FAO: Planning Department,
Welwyn Hatfield Borough Council

Ref: 6/2022/1078/COND
Date: 20/06/2022

HISTORIC BUILDINGS AND CONSERVATION ADVICE

RE: Northaw House, Coopers Lane, Northaw, Potters Bar, EN6 4NG

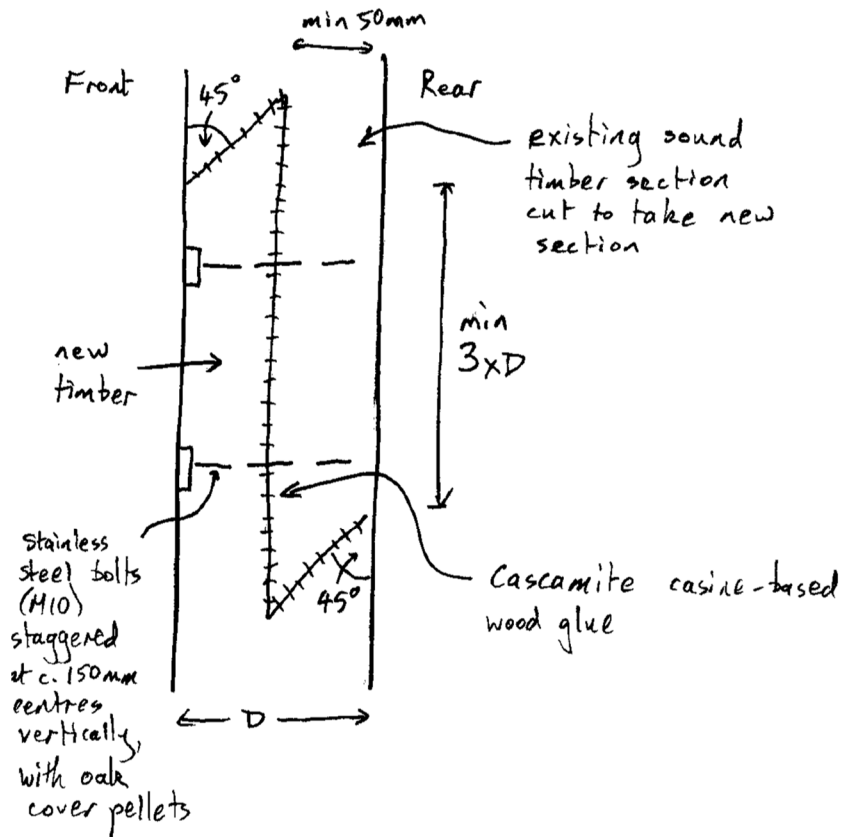
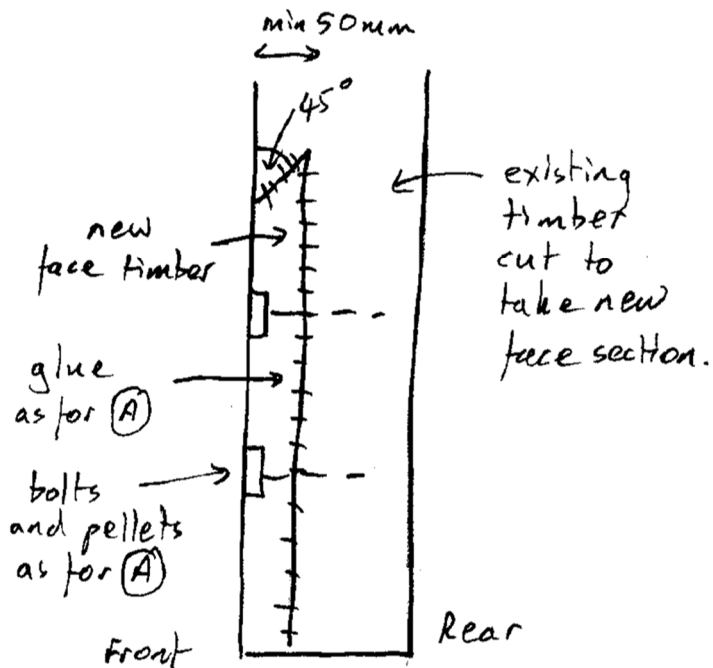
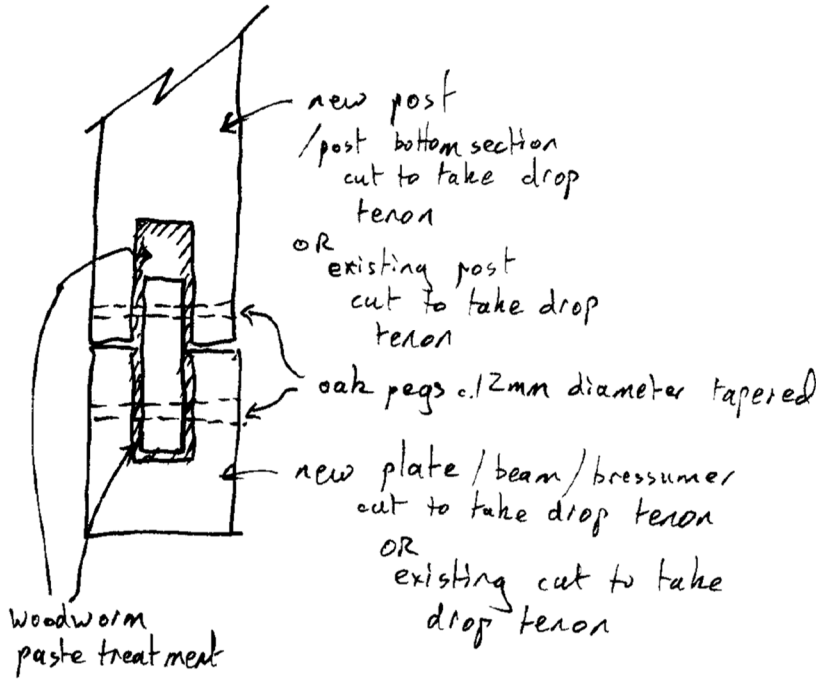
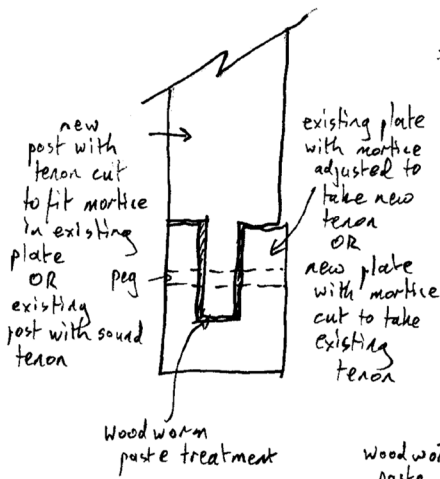
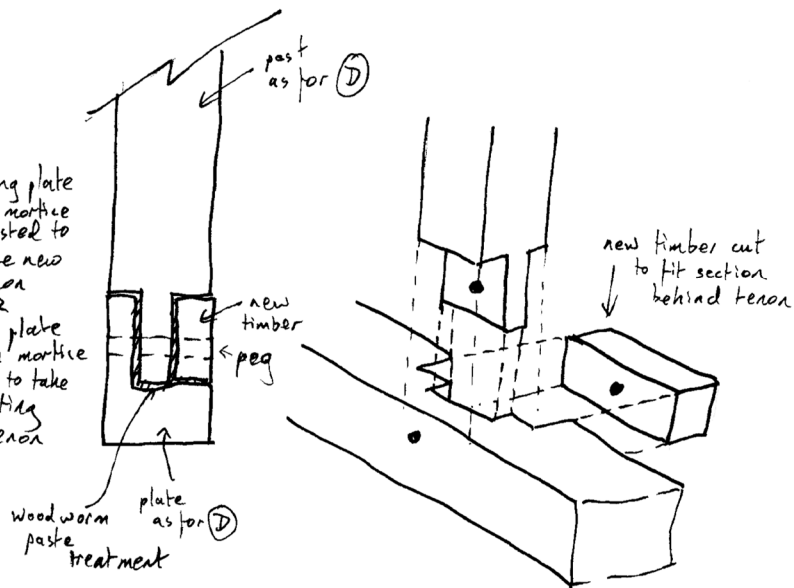
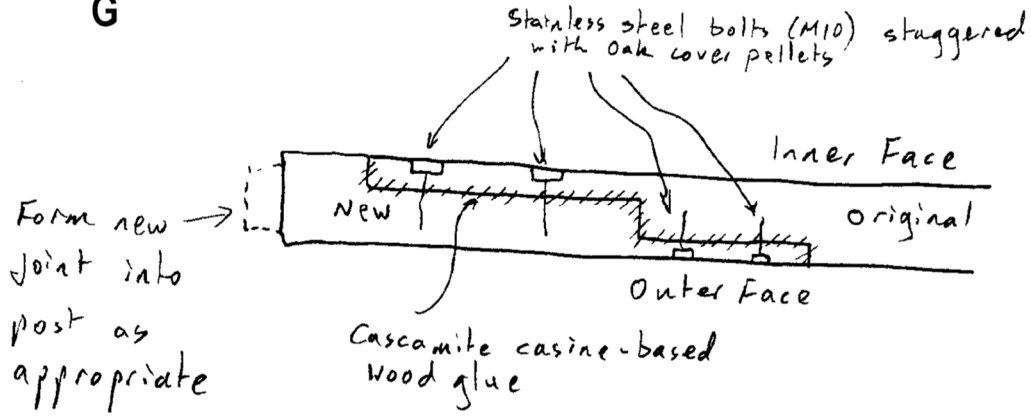
Timber frame repair details are provided but there is no drawing to show where these repairs are needed or a condition report to justify why they are needed.

PLAIN GLAZED AND BAR DESIGN OPTIONS

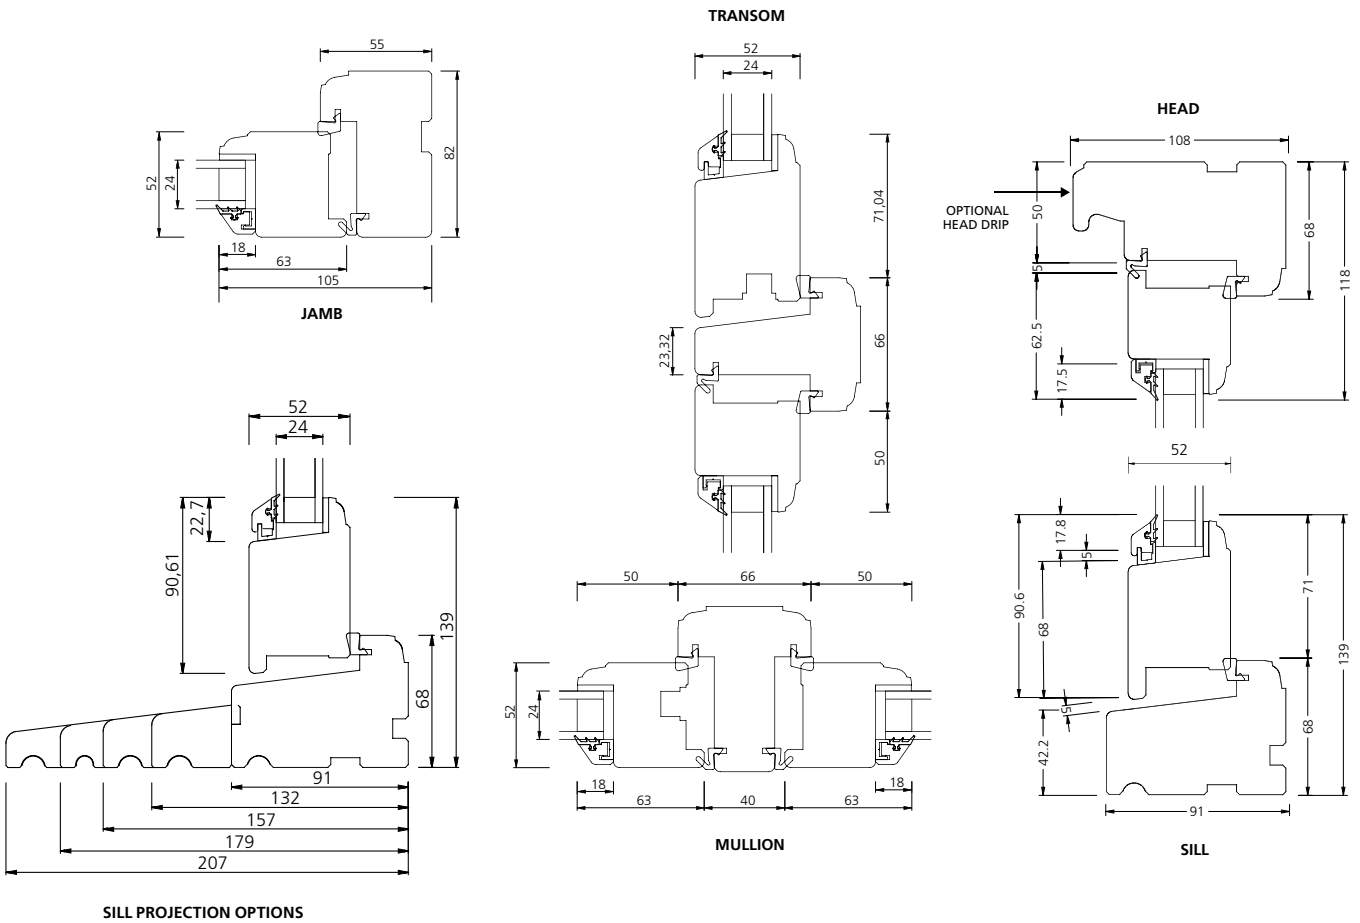
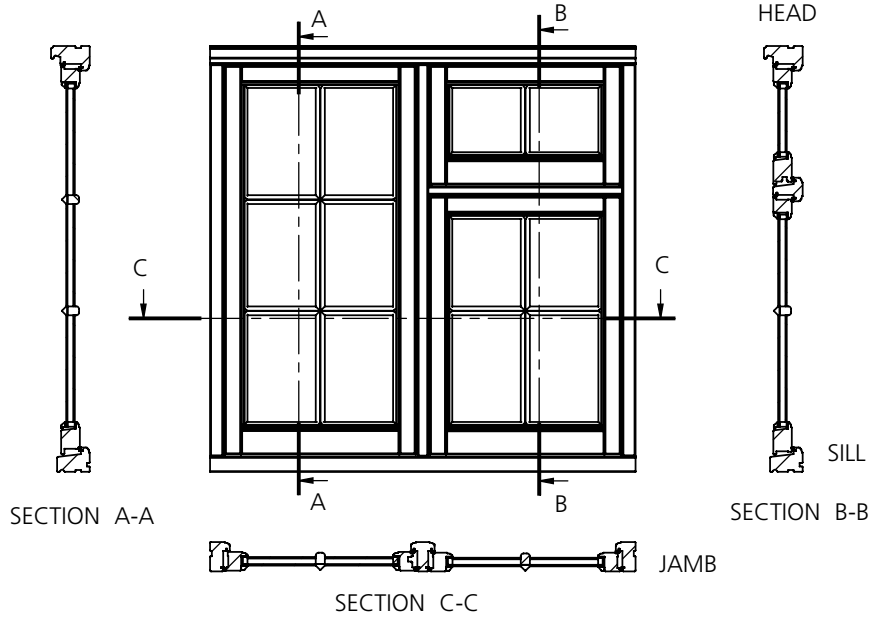
Details of casement windows are provided for the Stable Block (Jen Weld casements) but the elevation is shown with a top hung fanlight which differs from the approved drawings for side hung casements with four lights to each casement (rather than six shown in the detailed drawing). The approved drawings also included plain glazed windows at ground floor (east elevation). The materials sheets note the use of ‘plain casements’ but there are no details for these.

The sheets note the design of the windows including the Jeld Wen plain casements but no details are provided of this window type – the detailed drawing shows a multi-paned casement with a top hung fanlight. As noted above, some of the door details are also missing.

INSULUX
Longleat,
Reed Green

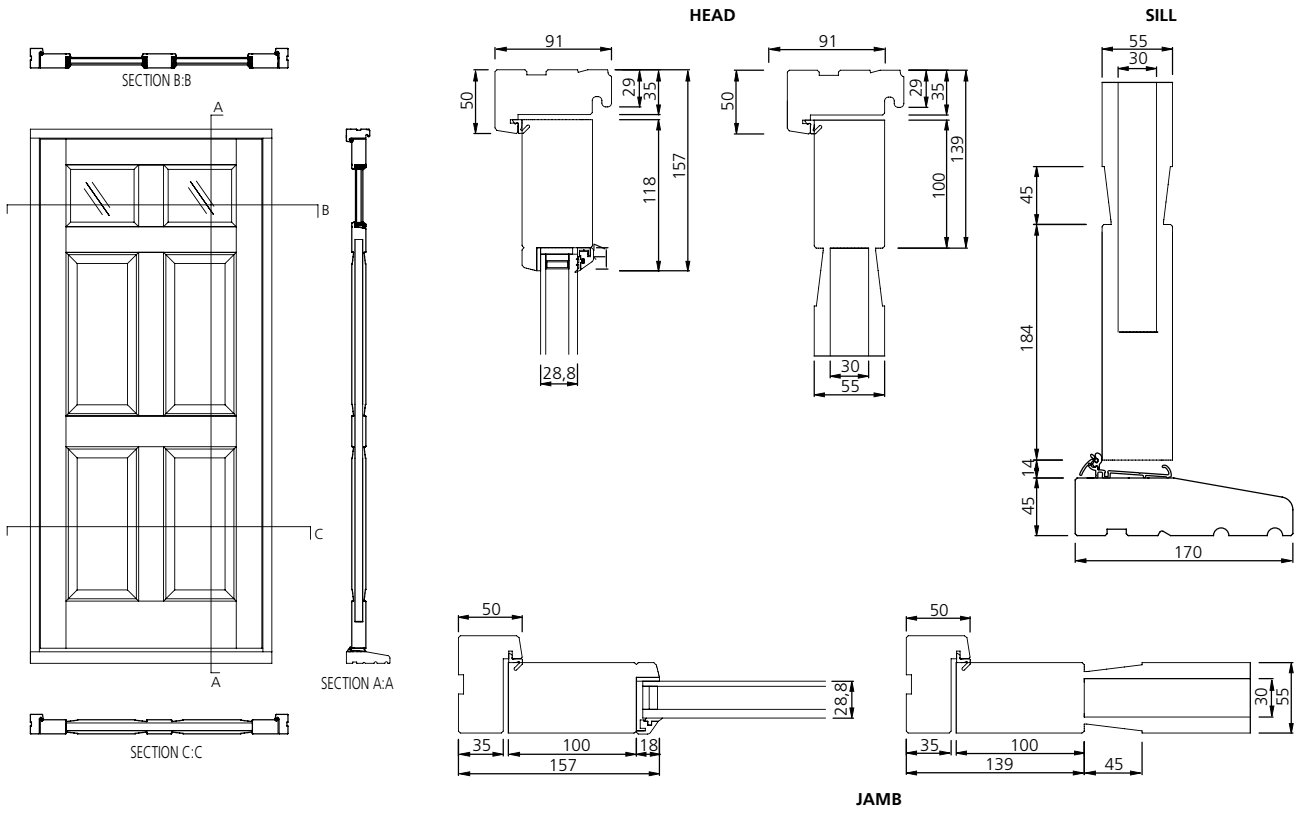
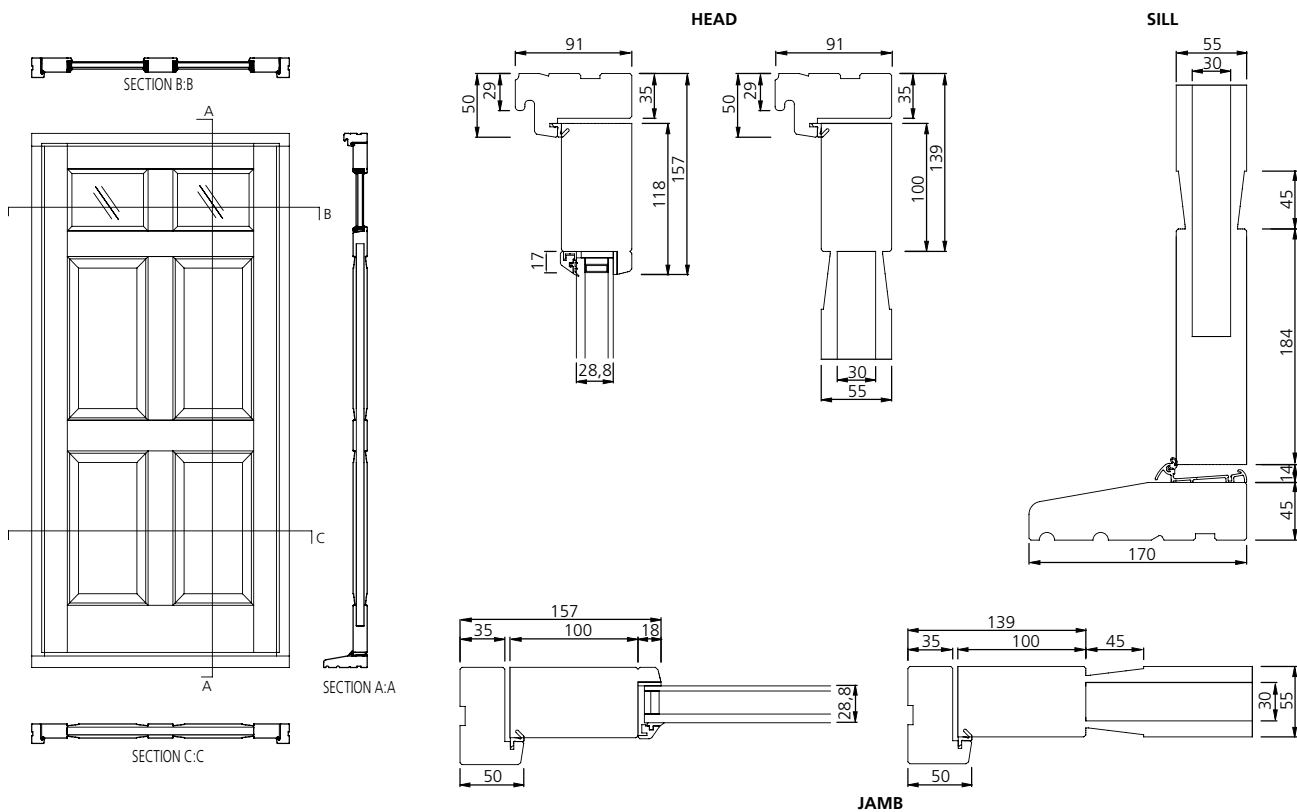
Details of a 'Longleat' external door are provided but the Stable Block is to have a 'Burlghley' door according to the materials sheet. The materials sheet for the main house also notes a 'Burlghley' door. No details of this door have been provided. In addition, it is not clear where on the main house this door is proposed as it would not be acceptable where there are surviving historic doors and this style (having consulted the website) does not appear to match the approved drawings or be appropriate for the main house.

Ventrolla Ltd	Drawing no. MJ/001
Northward House Coopers Lane EN6 4PS	
Date - 21 - 01 - 2020	
Elevation	Scale 1:10 @ A4
Box frame and Timber sash window	
Glass = 4:8:4 DGU Krypton gas Low E	
Painting Inside = white gloss Outside = White satin	
	Page 1

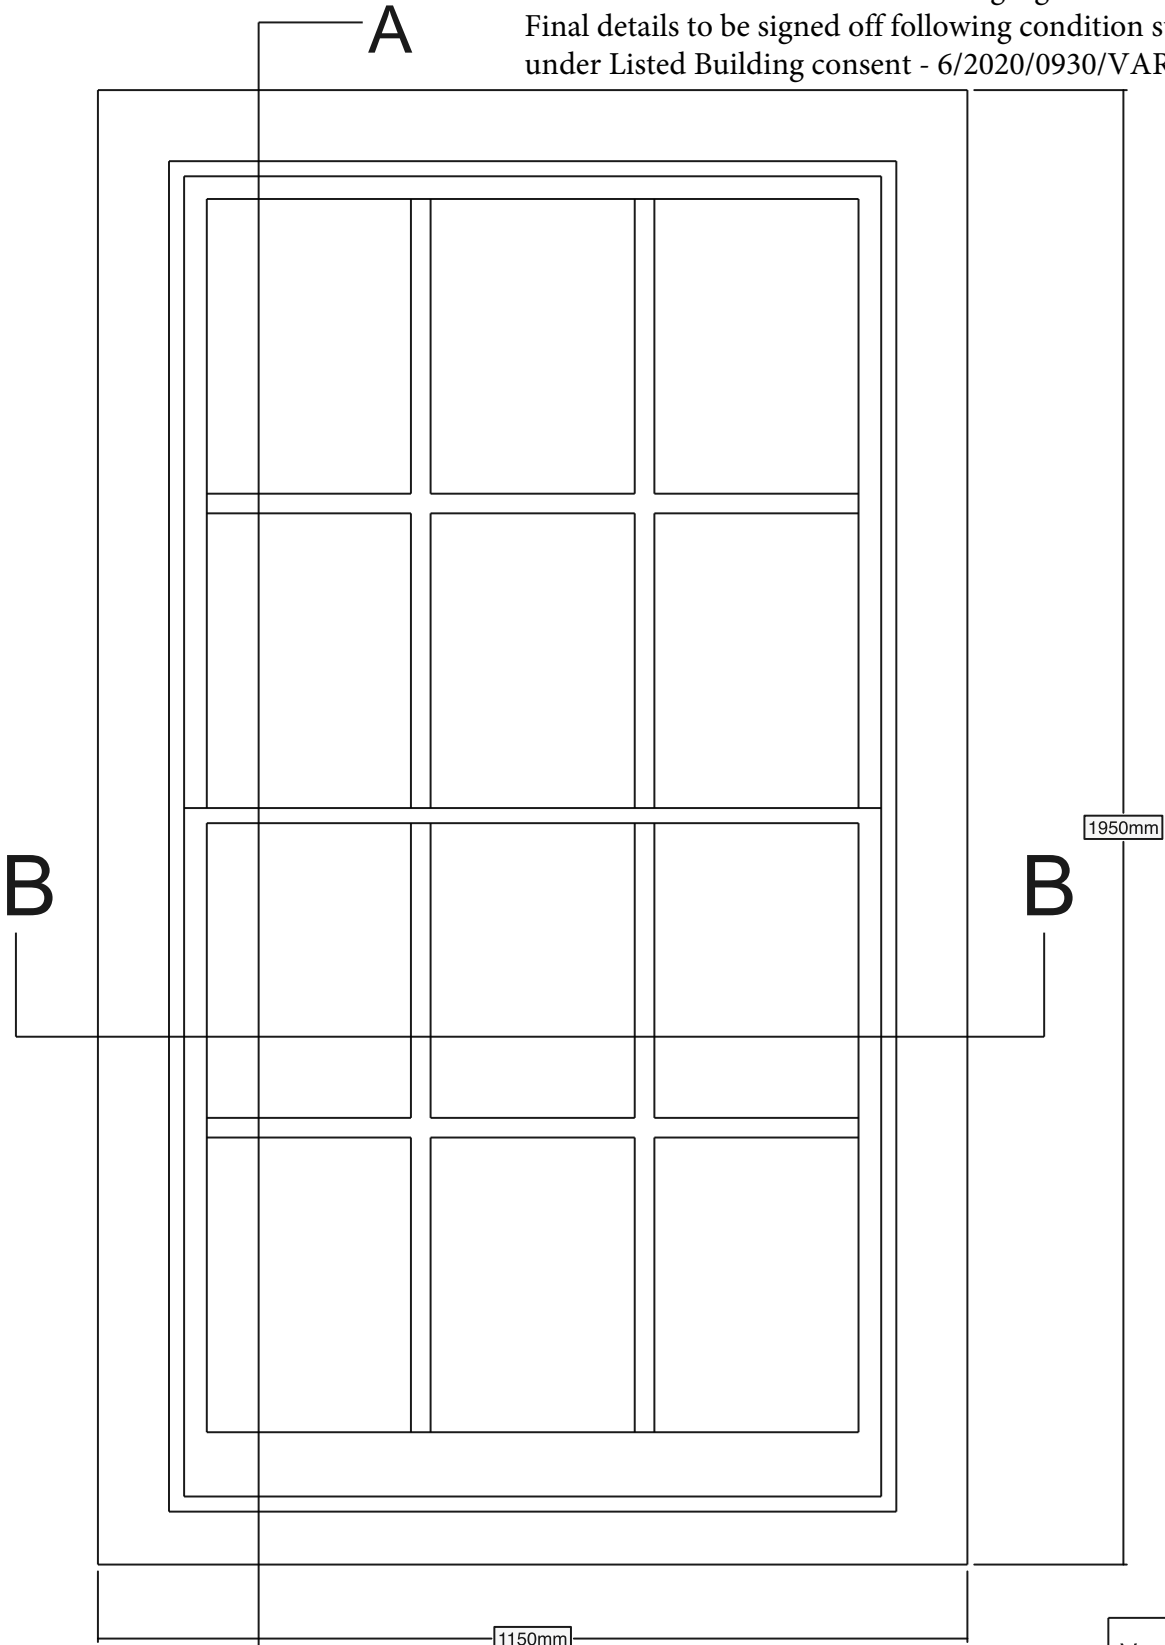
Window details submitted show a 6-over-6 sash window. The section drawings show 16mm double glazing, but the elevation drawing (MJ/001) noted that all windows will be single glazed to match existing and “final details to be signed off following condition survey carried out under Listed Building consent - 6/2020/0930/VAR”. The materials detail sheet for the main house notes windows will be Ventralla (as per the drawings) but these details show double-glazing.
